From: Clerk [REDACTED]
Sent: 10 May 2021 10:44
To: Michael Eastham <Michael.Eastham@arun.gov.uk>
Subject: FW: Planning Consultation on: BN/38/21/PL

Application No: BN/38/21/PL
Registered: 26th March 2021
Site Address: Land At Angels Nursery Yapton Road Barnham PO22 0AY
Grid Reference: 496255 104047
Description of Works: Construction of feature entrance wall set back from access to approved residential development.

| Drawing Title  |    | SITE_ENTRANCE_FEATURE_WALL_LAYOUT |            |

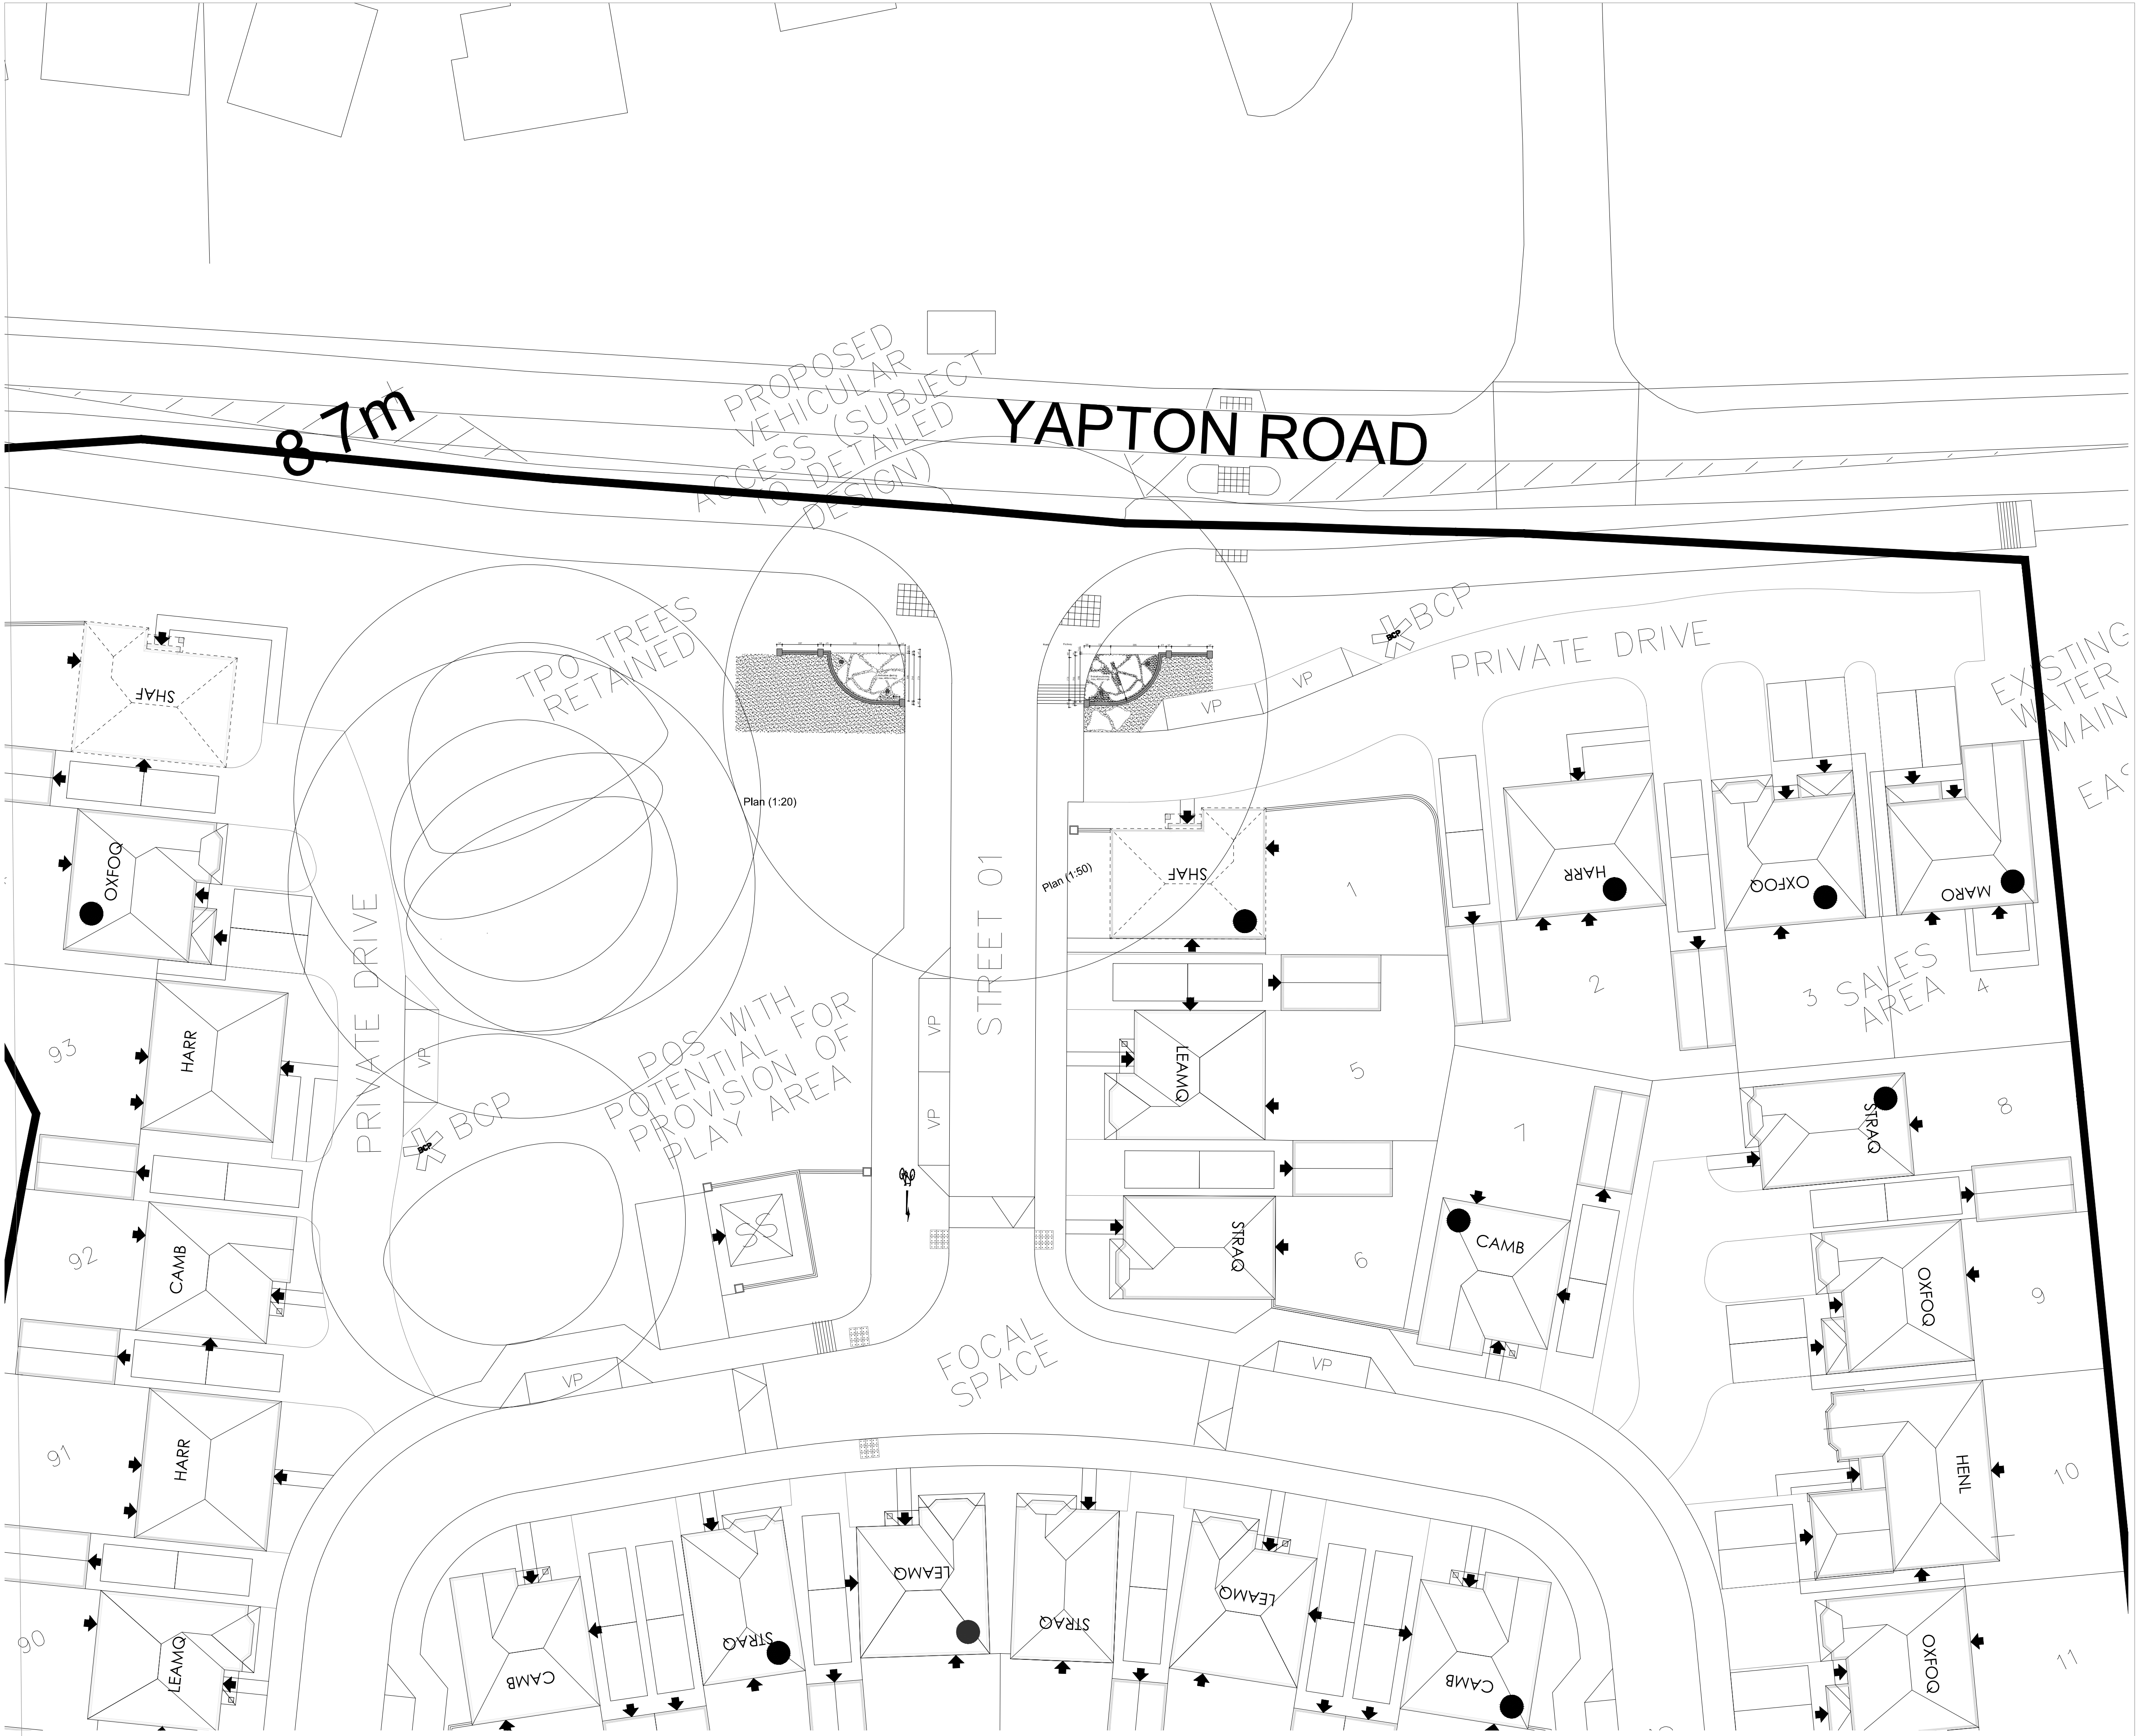
Further to our email exchange below and the further details supplied by Tilly I have now re-consulted the Planning Committee members and provided the additional planting Tilly confirmed would be included to soften the wall and the land around it then they Committee has no objection to the retention of the wall that has been built.

You will note the Committee weren't happy at they late change to the status of the application and also the fact that the wall has been constructed without consultation as we had always believed that the street scene would be landscaped not walled.

As far as the Committee was concerned no plans had ever been presented to them in any applications for the development that showed the construction of a wall it was always believed that the site boundary with the Yapton Road would be landscaped with trees and hedges so they feel they need an application that explains the reasons for this change before they can formally respond.

The submitted plans have been provided to enhance the entrance into the site, providing a more appropriate sense of arrival. The area to the front of the wall would be well landscaped, in fact, the planting proposed to the front of the wall would be enhanced when compared to the most recent approval for the wider site.
